# CITY OF PORTLAND BUILDING PERMIT

**PERMIT ID:** 2013-00829

has permission to **Build a new 225' long white cedar fence around part of the property boundary - 7.5' high**

SEARS FENCE 79 DEERFIELD RD, PORTLAND, ME
A-1.1 FENCE CONSTRUCTION DETAILS DRAWING NUMBER 1 OF 1
POLLARD BUILDERS PORTLAND, ME
DRAWN BY: J. B. POLLARD
DATE: 2013.04.23
SCALE: 1/4" = 1'

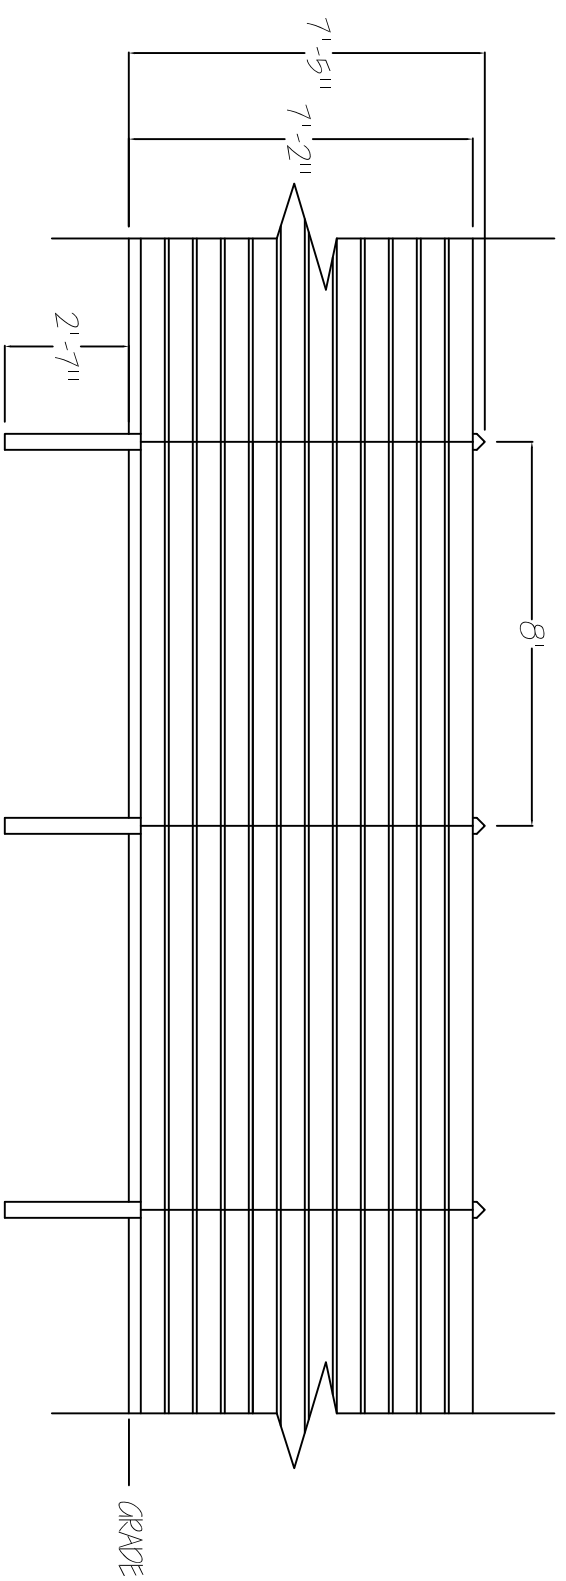
1) Section 14-426 requires that no fence along a street line or within twenty-five feet of a street line be more than four (4) feet in height. Please adjust your fence if necessary to meet the City's regulations.				
<b>Dept:</b> Building		<b>Status:</b> Approved	<b>Reviewer:</b> Tammy Munson	<b>Approval Date:</b> 05/17/2013
<b>Note:</b>		<b>Ok to Issue:</b> <input checked="" type="checkbox"/>
